Re: Railway (Metrolink - Estuary to Charlemont via Dublin Airport) Order [2022]
Metrolink. Estuary through Swords, Dublin Airport, Ballymun, Glasnevin and City Centre to
Charlemont, Co. Dublin

Submission

Re: Collins Avenue Metro Station

Slide 1 – Alternative Station Location at Albert College Park

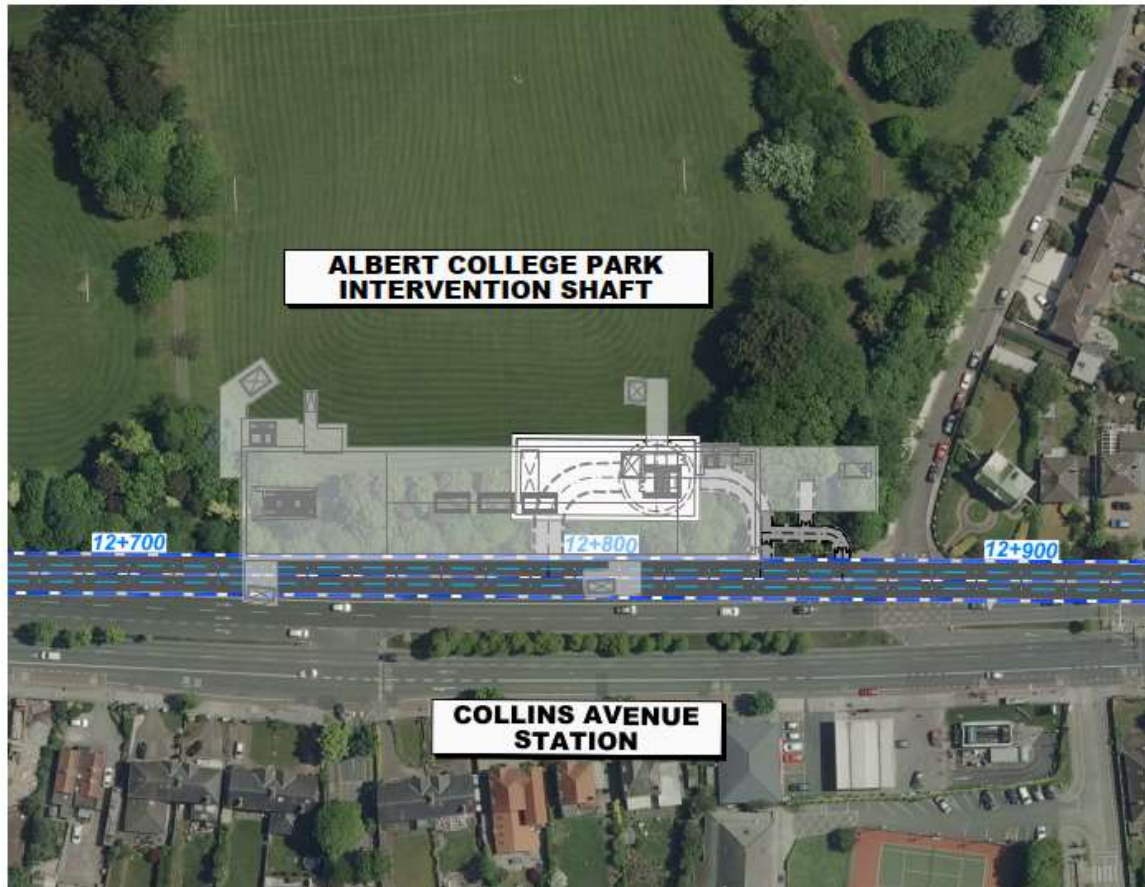
We submit based on considerations of service provision, community and environmental impact, both in the operational and construction phases, that relocation of the proposed DCU stop (also known as Collins Avenue Station as illustrated in diagram no.14 below) to a location of ultimately small visible footprint along the western periphery of Albert College Park is a more suitable option. This community strongly believes this would be a superior solution to the current design proposal to locate the station on the forecourt of our Lady of Victories Church on Ballymun Road.

It is our firm belief that with the same level of public and political support and motivation, that TII could revise the current station location, design plan, and construction timeframe as was the case at Griffith Park. We see no reason why, with station relocation onto the western periphery of Albert College Park along the main Ballymun Road, that the parkland could not also be reinstated overhead as is happening in the revised plan at Griffith Park. There are plans in place to construct a major intervention shaft and ancillary buildings on this location and this plan could be revised to upgrade the shaft to a functioning station serving DCU campus.
